May 12, 2021
Ron Bohannon
Tierra West, LLC
5571 Midway Park Place, NE
Albuquerque, NM 87109

**Re: Ativo Albuquerque LLC - 4500 Quaker Heights
Erosion and Sediment Control Plan
Engineer's Stamp Date 09/10/2020 (F11E019A)**

TRACT 3A COORS VILLAGE		DRAWN BY RMG
	4500 QUAKER HEIGHTS ABO NM 87120		DATE 9-10-20
	EROSION CONTROL DETAILS		DRAWING 2019064-SWPPP
	TERRA WEST, LLC 5571 MIDWAY PARK PL NE ALBUQUERQUE, NEW MEXICO 87109 (505) 858-3100 www.tierrawestllc.com		SHEET # SW-1
			JOB # 2019064

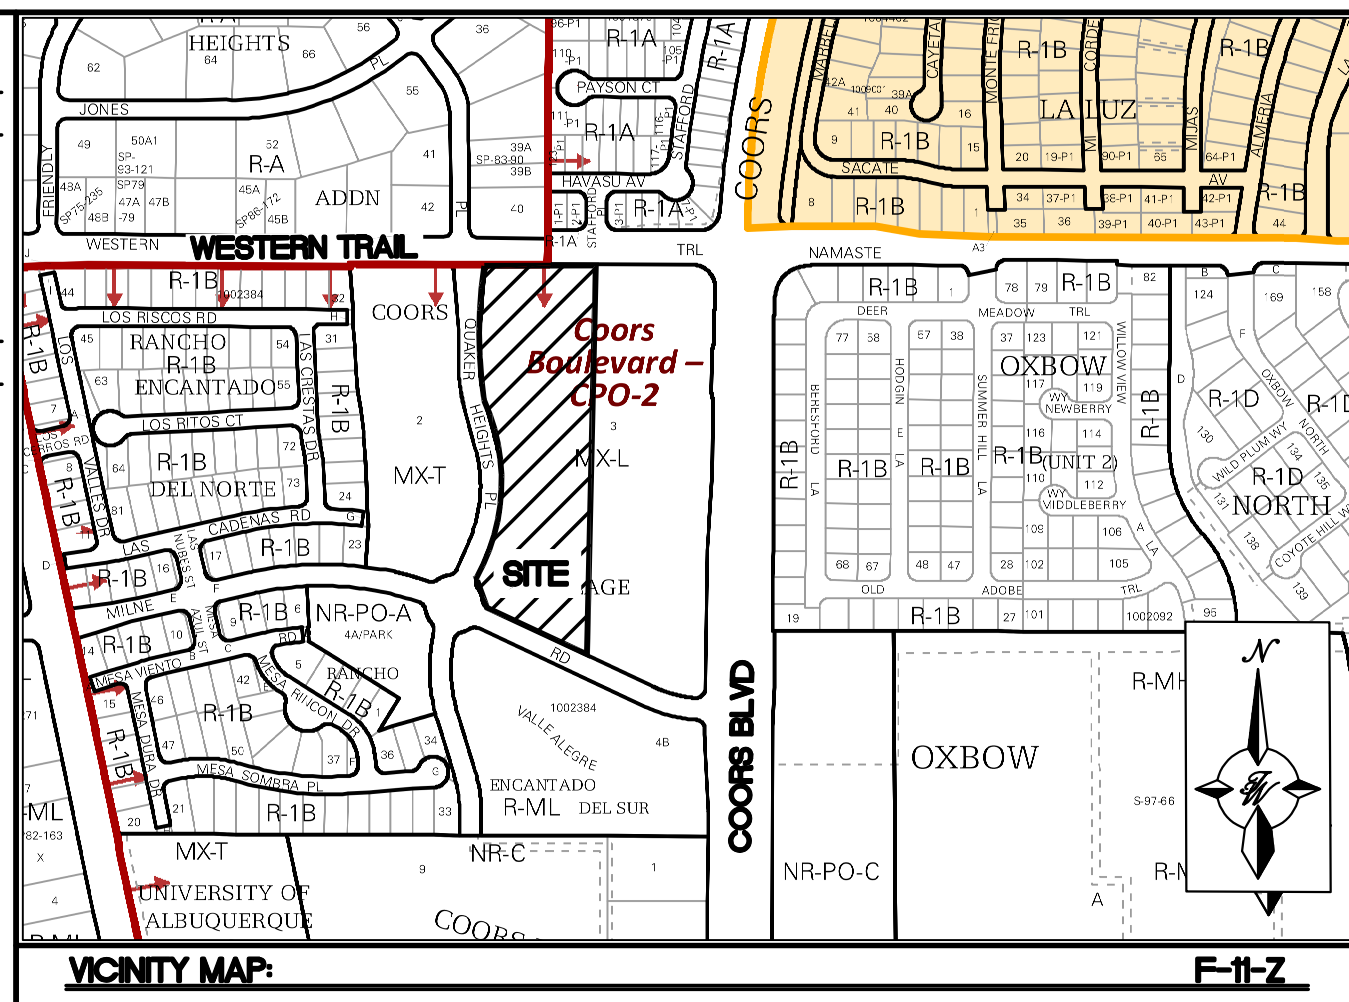
1. The "limits of disturbance" symbol in the legend is not shown anywhere on the plan. Clearly indicate the limits of disturbance. (CGP7.2.4.b.i);
2. The locations of structures and other impervious surfaces. (CGP7.2.4.b.v). The Site Plan can be used to satisfy this requirement and should be included in the SWPPP and the ESC Plan submittal.

3. Describe undisturbed and pre-construction ground cover (CGP7.2.4.e);
4. List operators on the plan, including name, phone #, and e-mail address. Include the developer/property owner's representative authorized to make changes to contract documents, plans, and specifications per CGP 7.2.1. If there are multiple operators describe the area of control for each. State whether the operators will share a SWPPP or if they will each have separate SWPPPs;

5. Identify stormwater team members responsible for sediment removal, BMP maintenance, and inspections on the plan, including name, phone #, and e-mail address (CGP 7.2.2). Provide the stormwater team for each operator;

6. Describe the nature and extent of construction activities for each operator (CGP 7.2.2.), including a) nature of construction activities, b) size of the property, c) size of disturbed area, d) description of construction support activities, and e) size of maximum disturbed area;

7. Stabilization measures (CGP 7.2.6.b.vi), including a) **Specific** vegetative and nonvegetative practices, b) deadlines, c) beginning and ending dates of the seasonably dry period, d) procedure to comply with The Weed Removal Ordinance (§ 9-8-1). The landscape plan can be used to satisfy this requirement and should be included in the SWPPP and the ESC Plan submittal. It should include the street right of way adjacent to the site;

8. Soil information – add a table with name type, particle sizes, and Erodibility factor (CGP 2.1.1).

9. Update the engineer's stamp date each time the plan is changed.
10. City Standard ESC Notes attached.
11. The ESC Plan can't be approved for Building Permit until the property owner's NOI has been reviewed and approved by City Stormwater Quality.
